FINAL DRB DECISION PACKET

Development Name: SPOUT SPRINGS CHURCH OF CHRIST
Development Type: COMMERCIAL SITE PLAN REVIEW
Date: MARCH 14, 2018

**The above referenced application
is CONDITIONALLY APPROVED as listed below.**

SITE PLAN

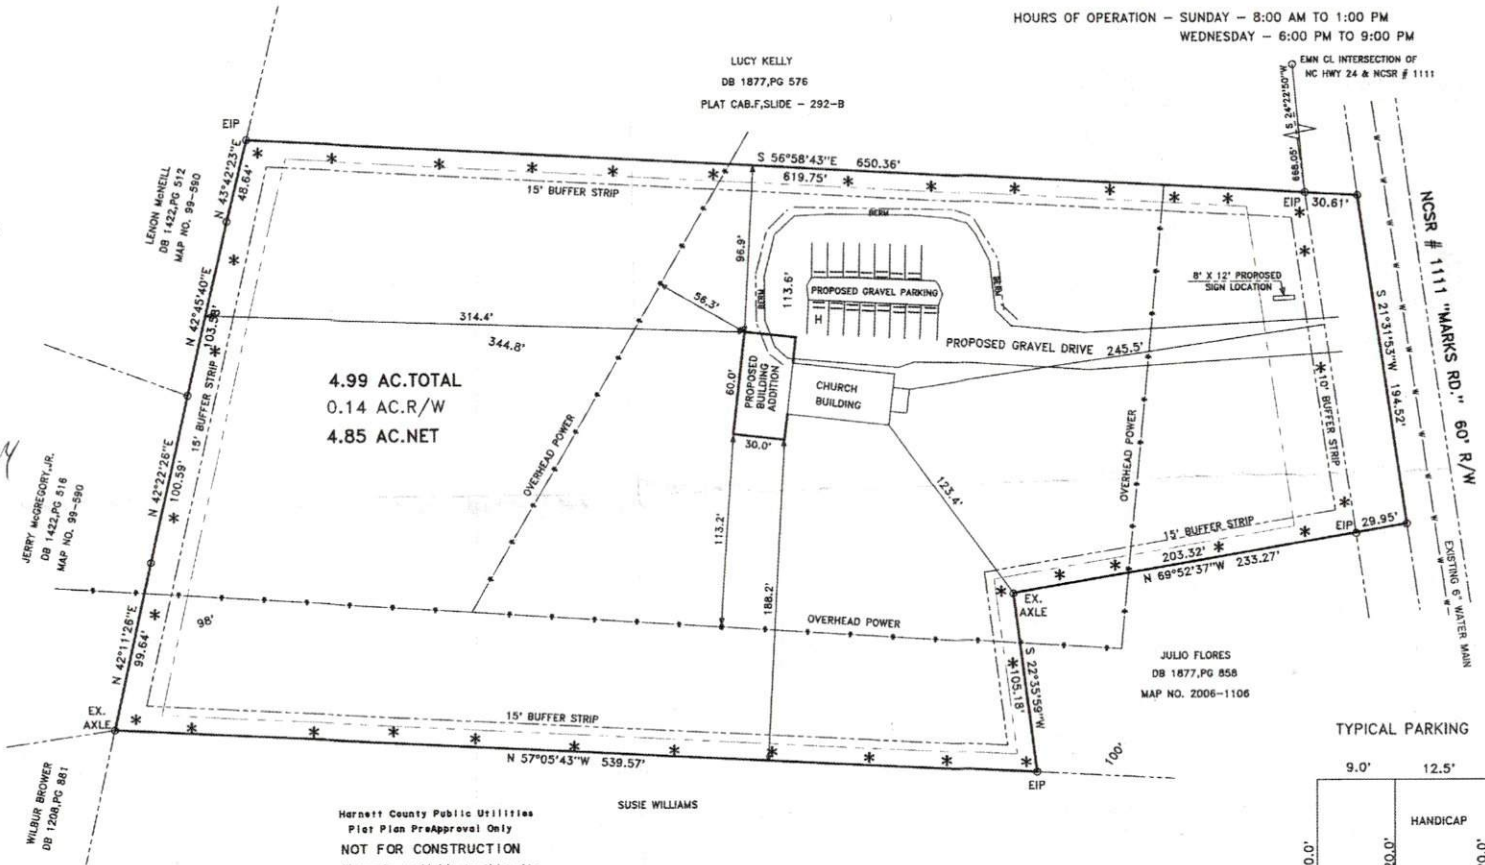
<p>Engineering (910)893-7555 Amanda Bader, abader@harnett.org</p> <p>Approve:</p>	<ol style="list-style-type: none"> 1. Provide area of disturbance. Is it less than one acre? 2. Submit grading plan.
<p>Fire Marshal (910)893-7580: Rodney Daniels rdaniels@harnett.org</p> <p>Approve:</p>	
<p>GIS/E-911 Addressing (910)893-7523: GIS@harnett.org</p> <p>Approve:</p>	
<p>Planning Department (910)893-7525: Jay Sikes, Landon Chandler jsikes@harnett.org, lchandler@harnett.org</p> <p>Conditionally Approve:</p>	<ul style="list-style-type: none"> • There are a few misspellings within the "Note" section. • Note section should reference Unified Development Ordinance and Art VII, Sect 9.0 • FYI... sign will require an additional review. • Submit hard copy with owner signature.
<p>Public Utilities (910)893-7575: Shane Cummings scummings@harnett.org</p> <p>Conditionally Approve:</p>	<ul style="list-style-type: none"> • \$290 Review Fees are due to HCDPU. • Note who will install the new fire hydrant. If a licensed private utility contractor is to install the fire hydrant, a Three Party NCDOT encroachment will be required and sealed drawings with the HCDPU notes and details on the plan(s). • Note the location of the existing water service and size. Include NC811 contact information.
